Your Ref: OWPC16973
Our Ref: FG/201/17/HH 11-12-2017
Please ask for:
Mark Jones

Two storey side extension (resubmission following FG/119/17/HH).
54 Ocean Drive Ferring

Ref: FG/201/17/HH Proposed Works at 54 Ocean Drive, Ferring.

Block Plan. Scale 1:500

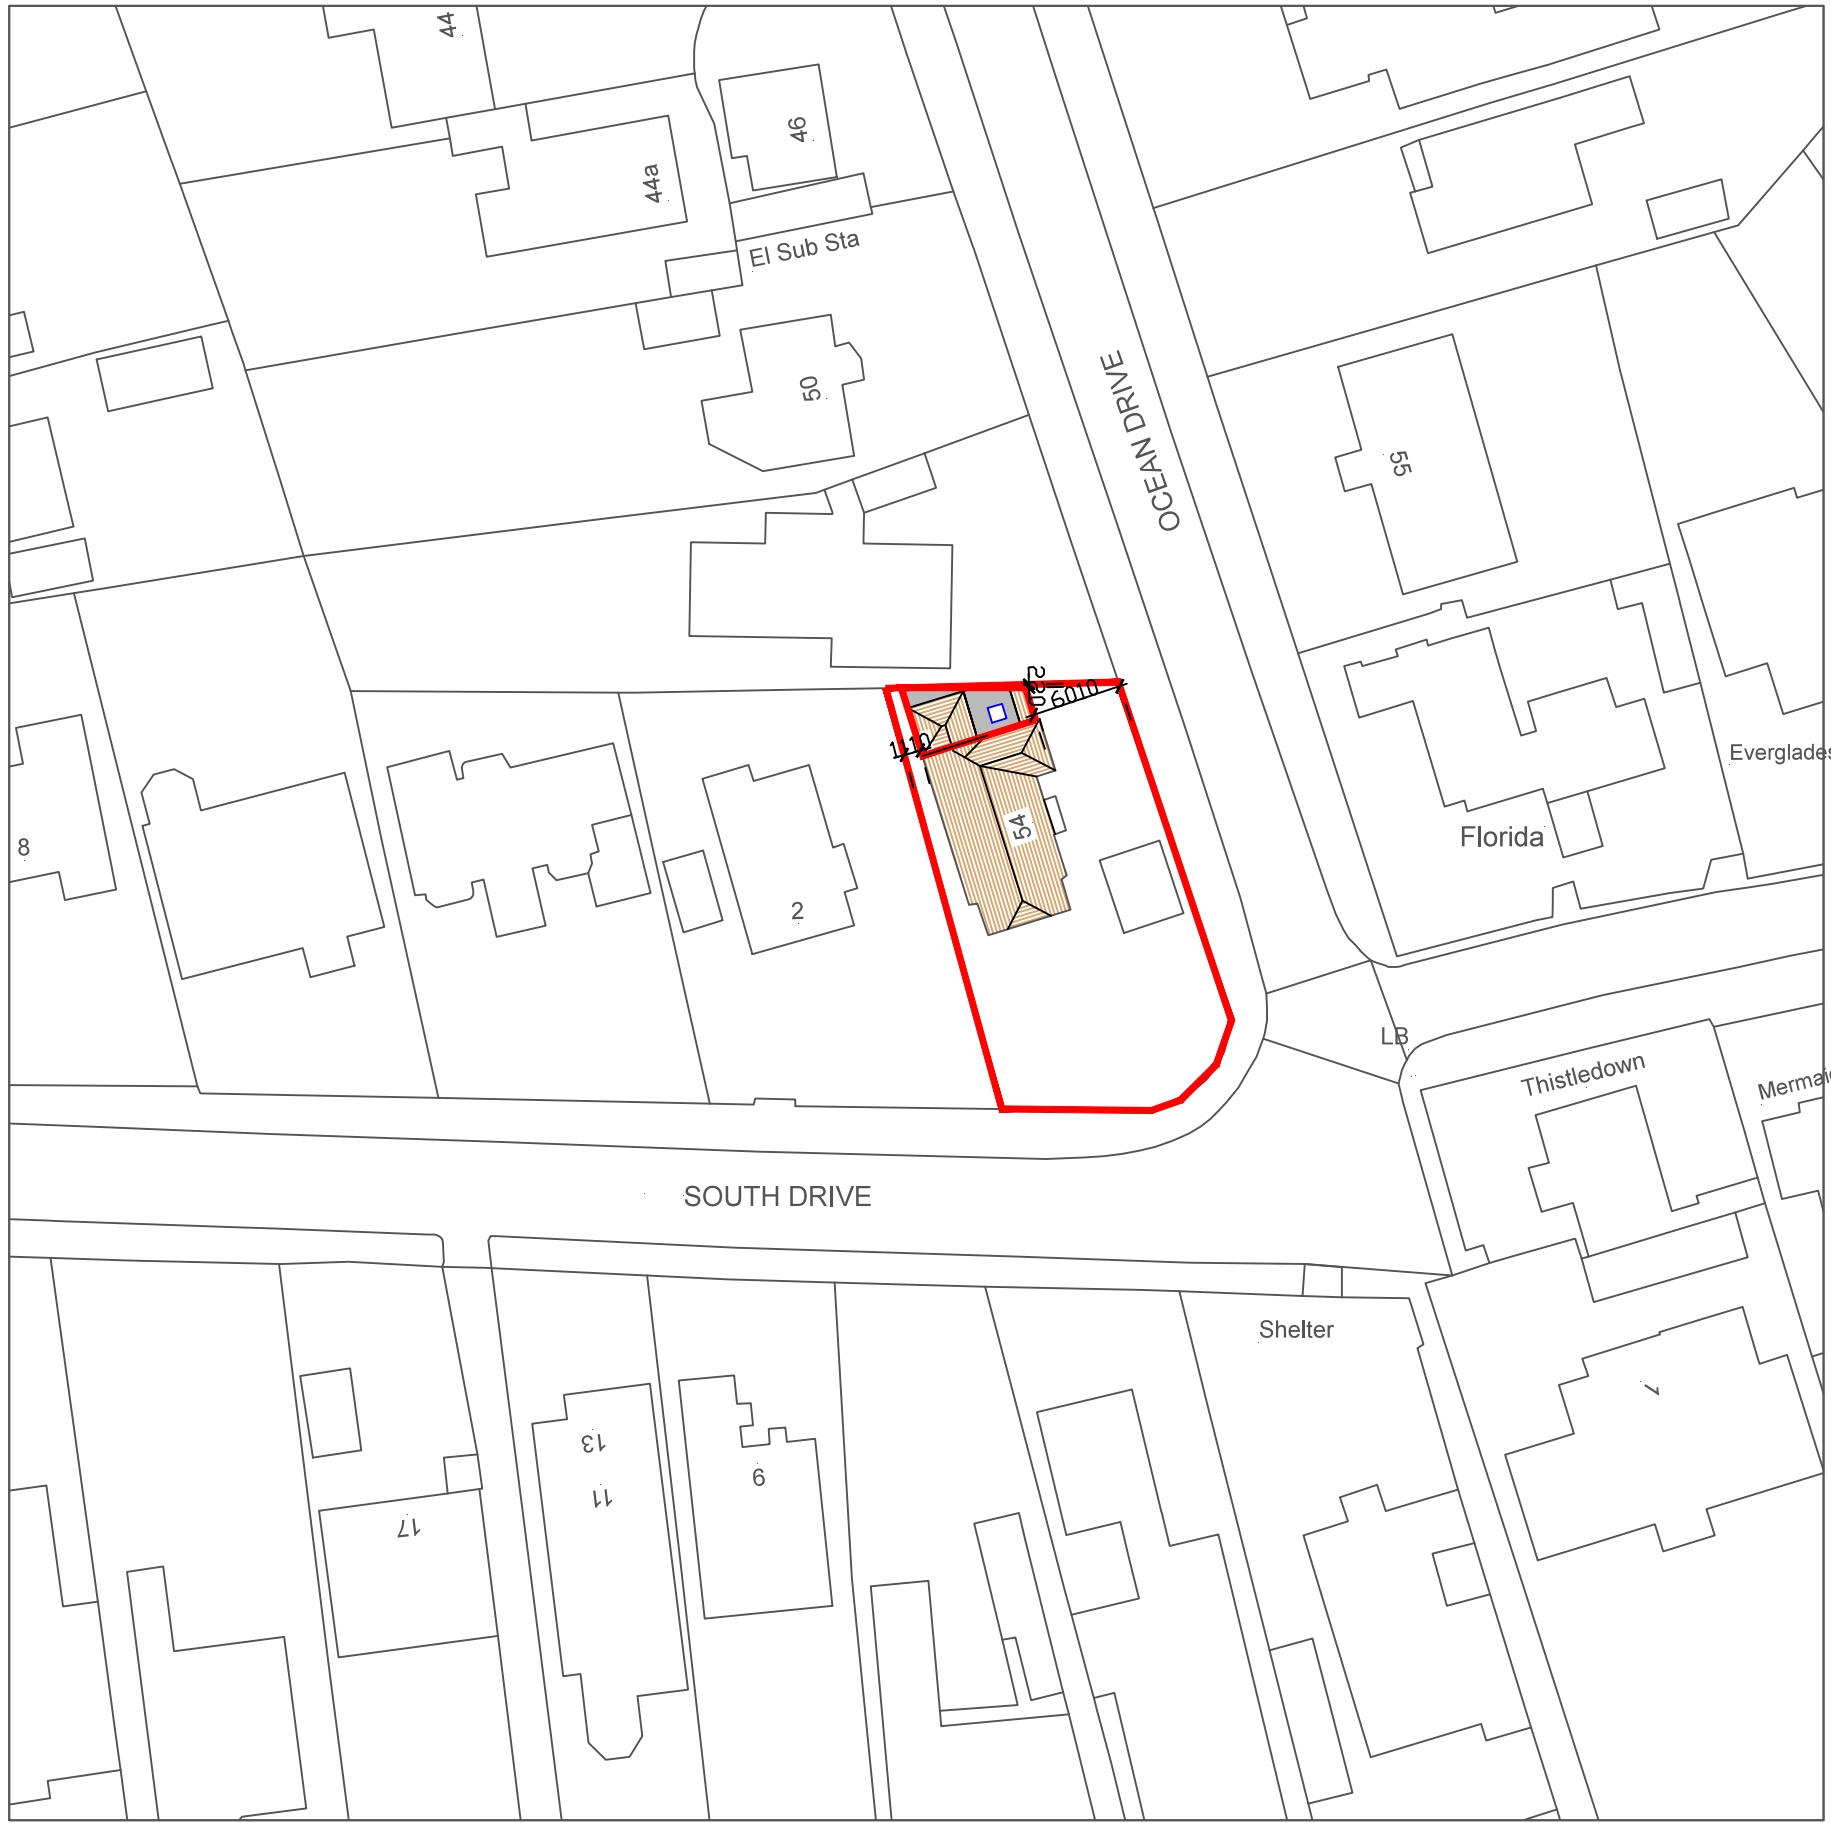
Fourthly, the gap between the properties would be reduced to little over a metre making it overbearing and claustrophobic and totally out of character with the village where properties normally enjoy significant spaces between them. The proposed extension is too big and too close to the boundary.
